Inspector's Report ABP-322958-25

Development	Link road, expansion of bus depot, culverting of drain, revised roads access, active travel upgrades and associated development
Location	Bus Éireann Depot, The Crescent Junction and Coosan Point Road / Southern Station Road, Athlone, County Westmeath
Local Authority	Westmeath County Council
Type of Application	Application for approval made under Section 177AE of the Planning and Development Act 2000, as amended
Prescribed Bodies	Uisce Éireann Minister for Housing, Local Government and Heritage
Observers	Anne Hanley Barry Flannery Eileen Gallagher Joseph Gallagher Louise Heavin

Drawing file: Drawings / 120278-5001 PL1 Vegetation to be Removed.pdf

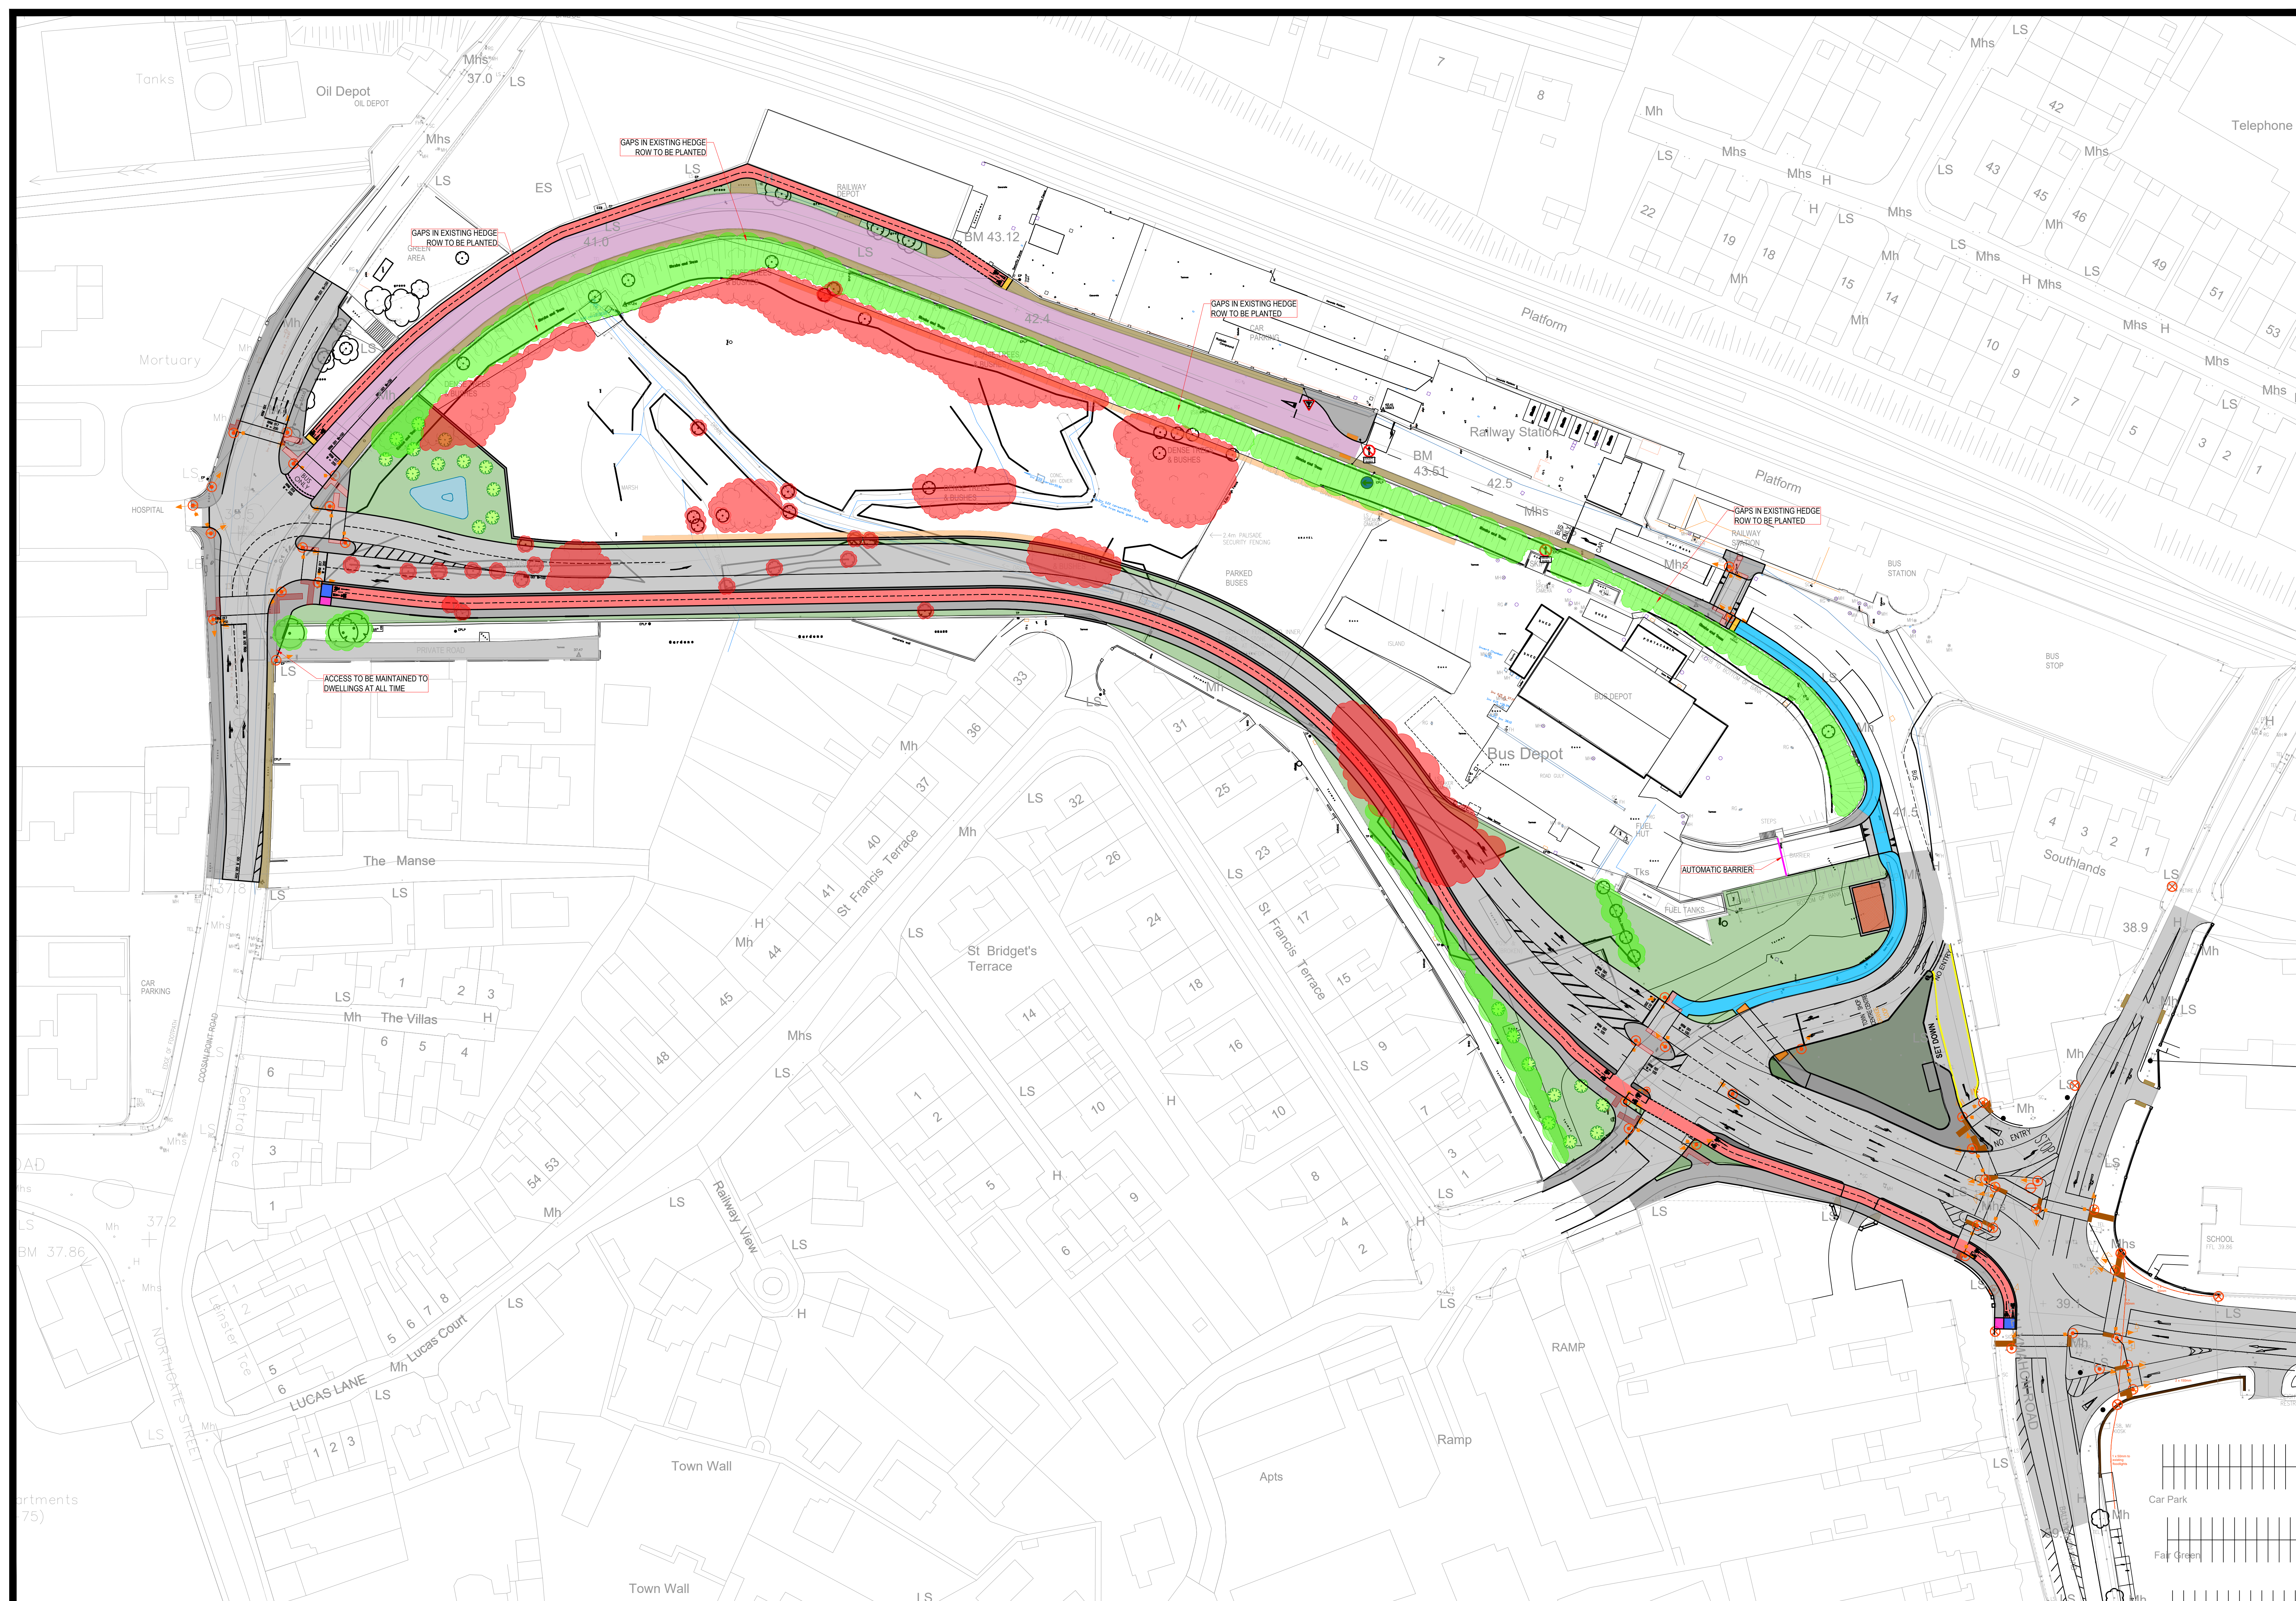
- excessive loss of trees is proposed, which would increase noise impacts and light intrusion to neighbouring properties;
- the intended removal of hardwood native trees conflicts with the provisions of the National Biodiversity Action Plan;
- there are conflicts between the details within the vegetation to be removed drawing (no.120278-5001) and the habitats drawing in the NIS;

- tree removal has been addressed as part of the Ecological Impact Assessment;
- tree removal has been kept to a minimum, with several trees required to be removed to facilitate boundary wall construction;
- replacement tree planting would be undertaken along the project boundaries and green spaces, including the wetland area to the west of the site;
